Your Ref: OWPC23743
Our Ref: K/19/19/HH 25-06-2019
Please ask for:
Zac Denton

Two storey rear extension with a small canopy projecting the footprint to the front.
Demolition of existing living room and additional first floor for habitable use with
alterations to fenestration.

Little Tangley Middle Way Kingston Gorse East Preston

Thank you for your internet representation made on 23rd July 2019 which has been recorded
as '**an objection**' with the comments as follows:

Drawing Title
**Existing and Proposed
Floor Plans**

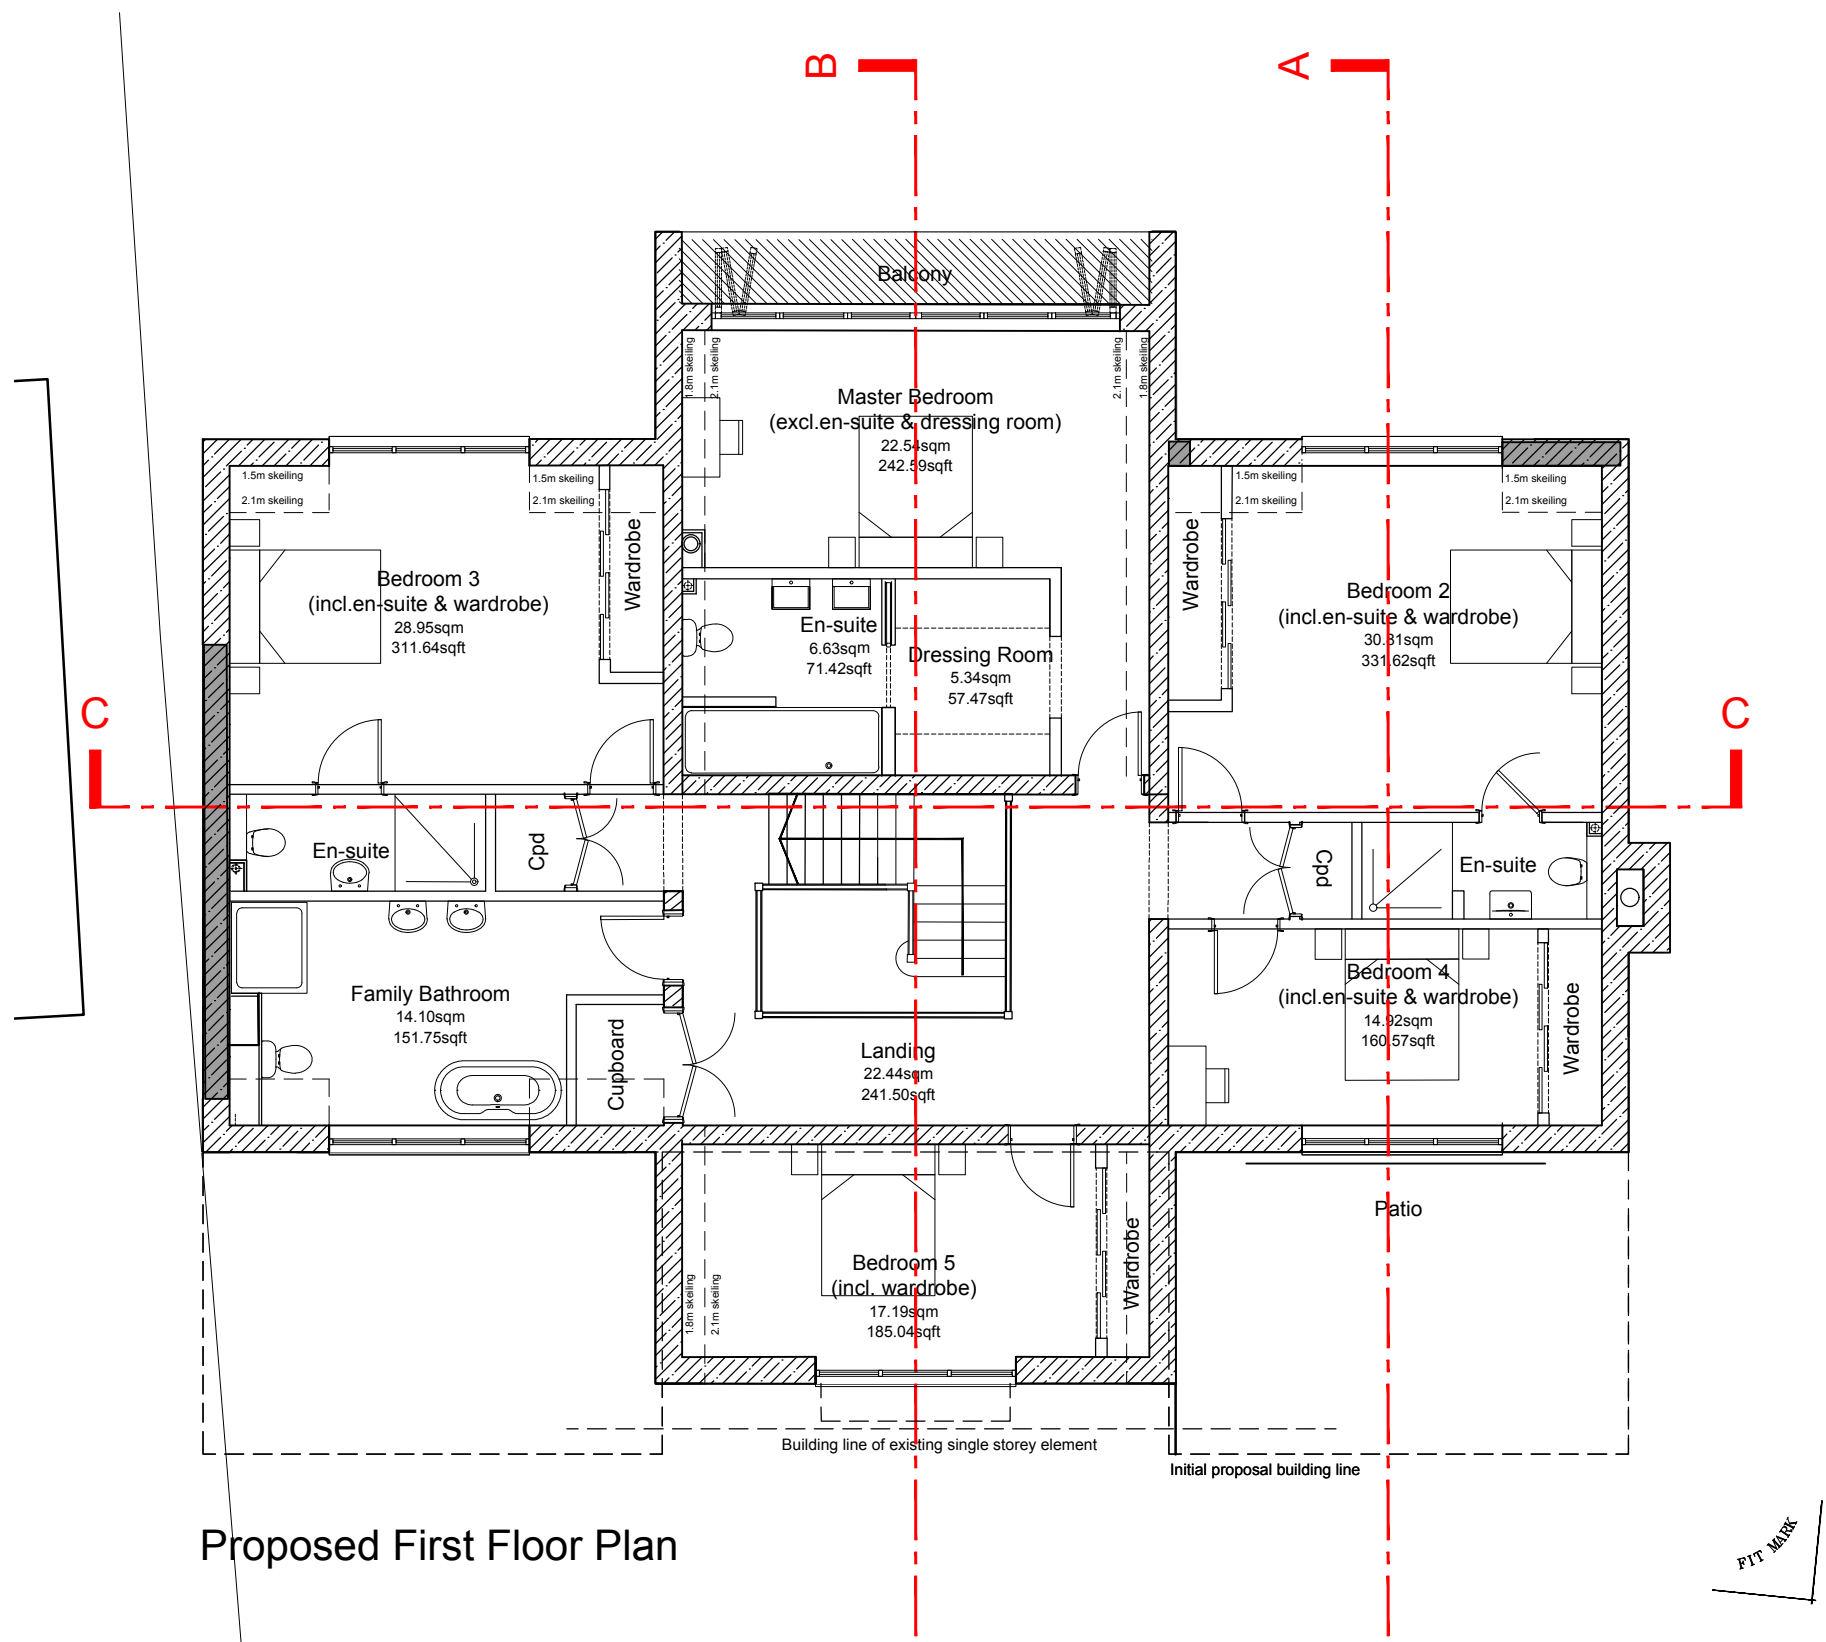
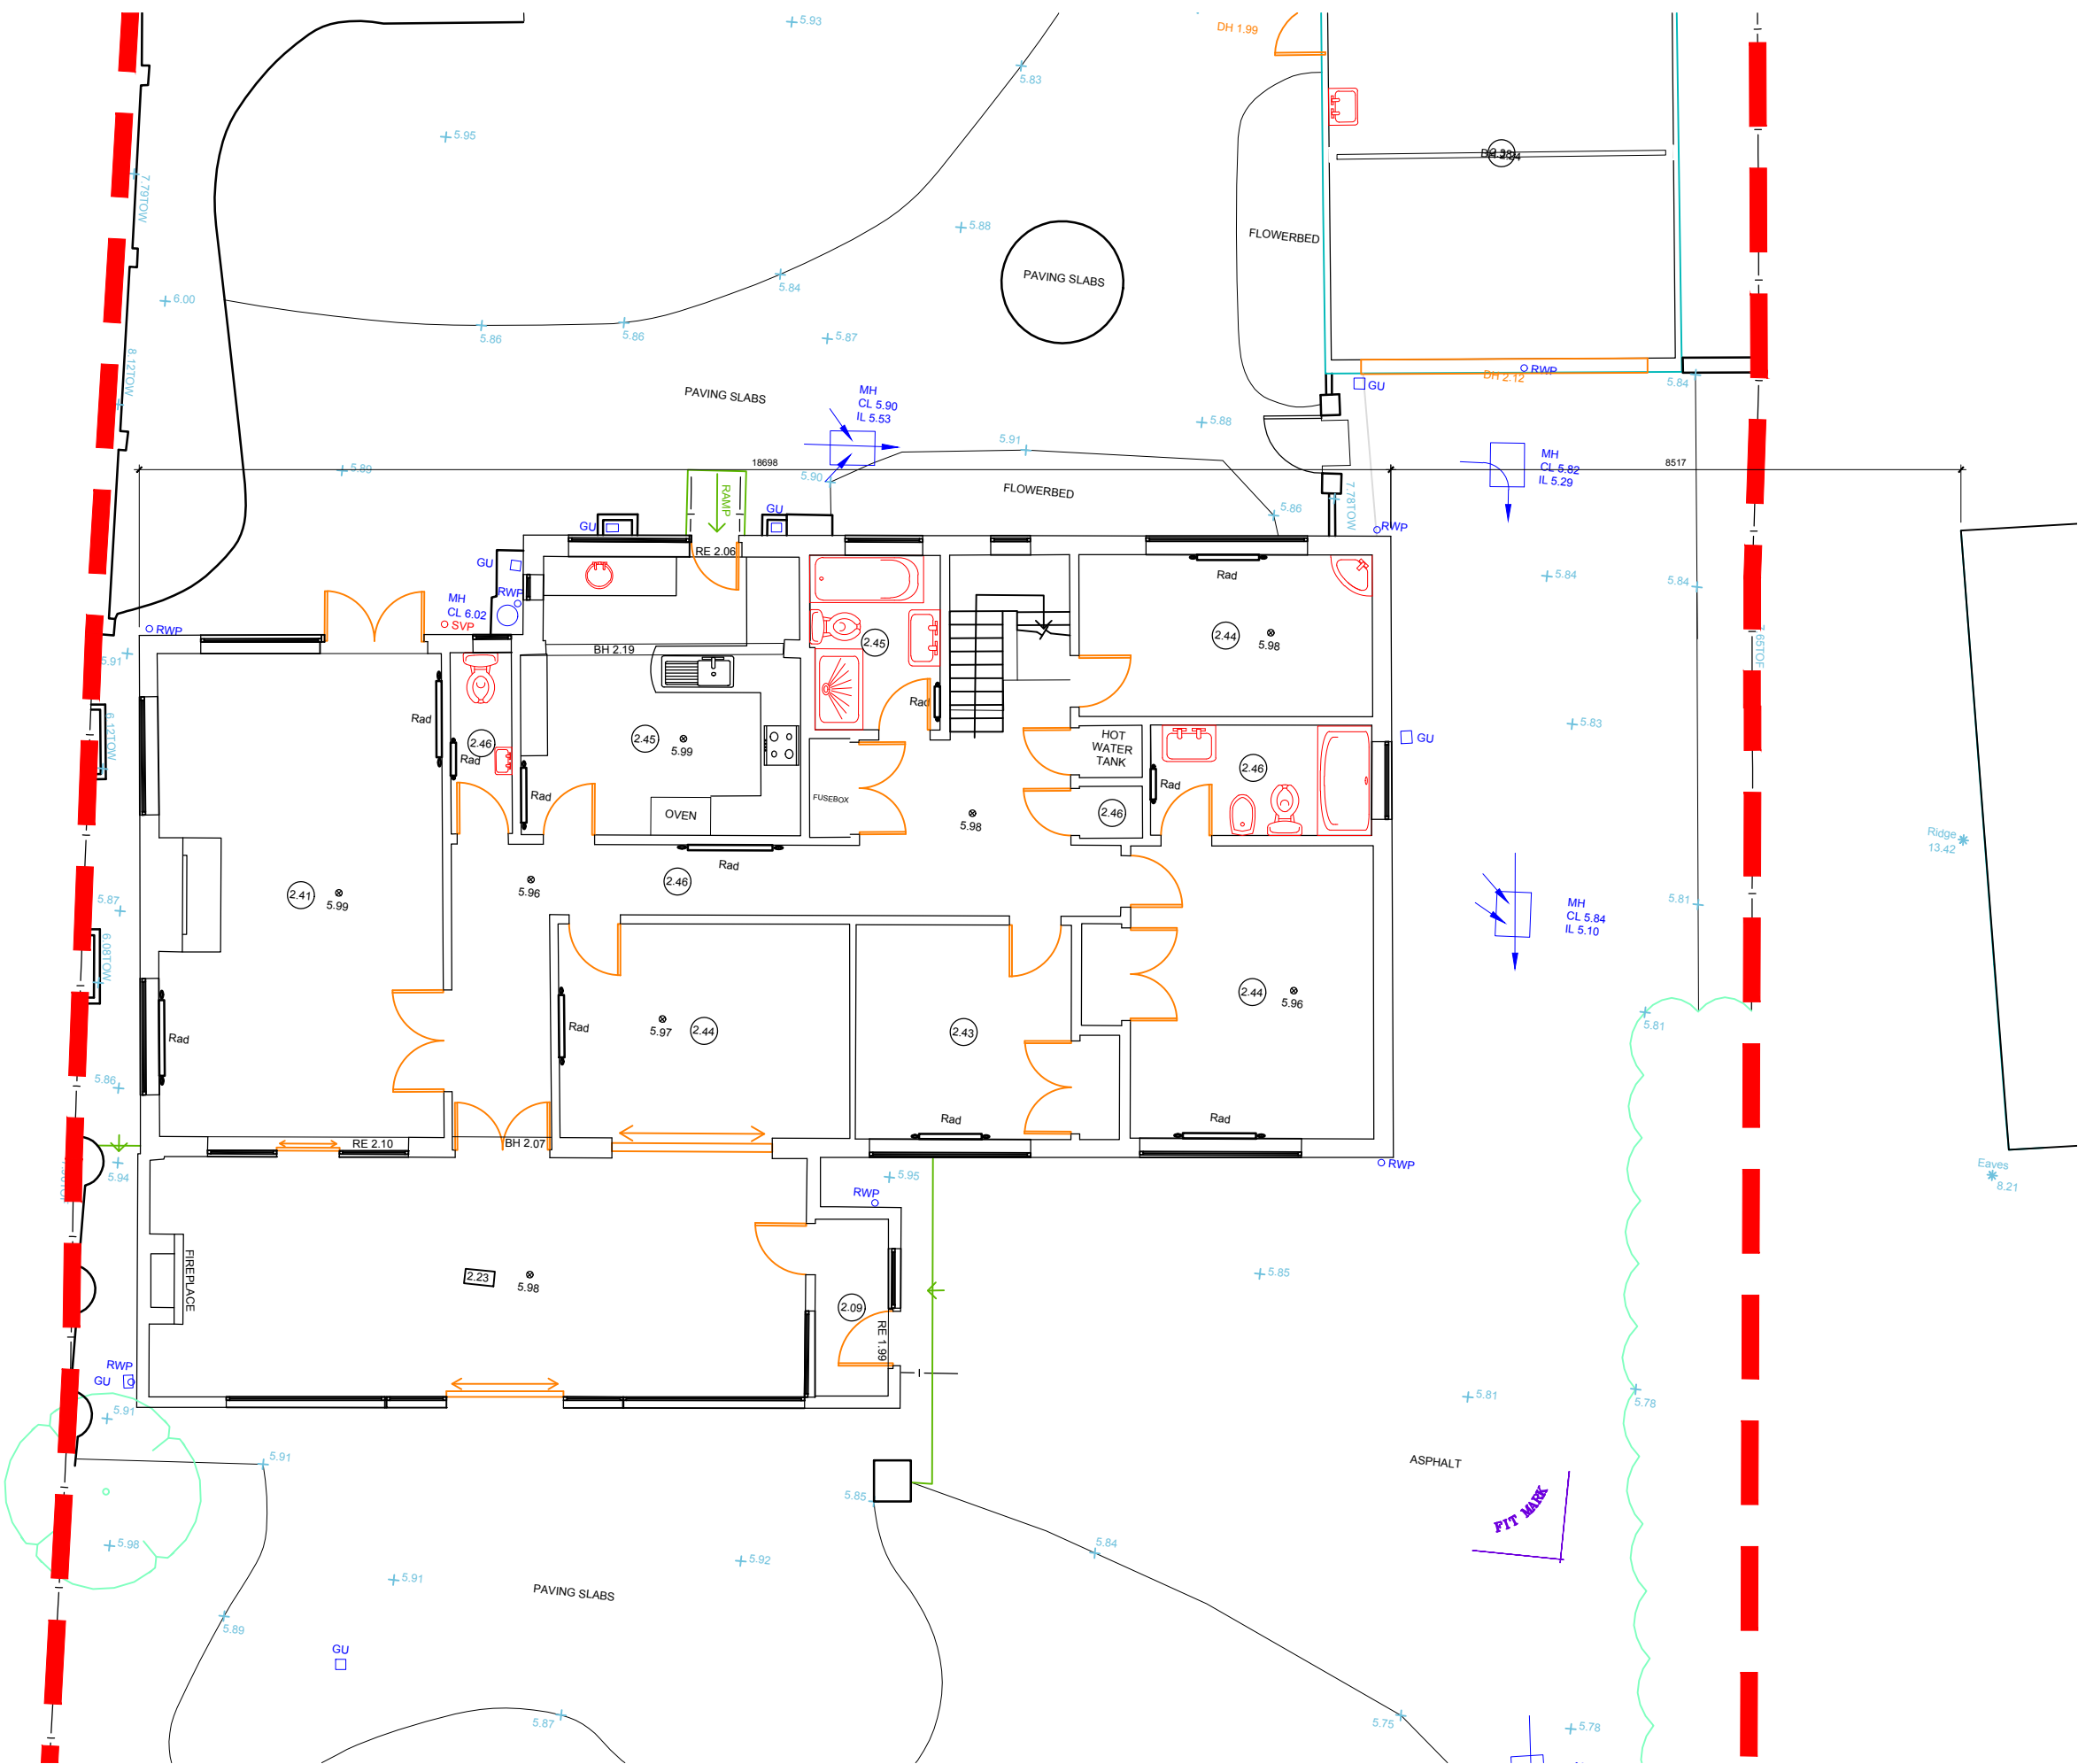
The proposal for this to be replaced by a so-called "small canopy" - a two storey entrance with a porch/hallway, a fifth bedroom immediately above, and a gable extending almost to the full ridge height - will substantially and adversely impact on our light. The proposed two-storey western flank and gable will be directly in the line of our kitchen window, to the south of the original line of the bungalow.

Unlike any other house in Middle Way, including Little Tangley, Clova only has a garden to the south (ie. between the road and the house). At present, as we relax in and enjoy our garden, we are not overlooked at all by the occupants of Little Tangley, but under the proposal for a front upper storey "small canopy", within the footprint of the current single storey sunroom, we would be overlooked from the first floor window of the proposed fifth bedroom. We consider this would be intrusive and would have a material impact on our privacy.
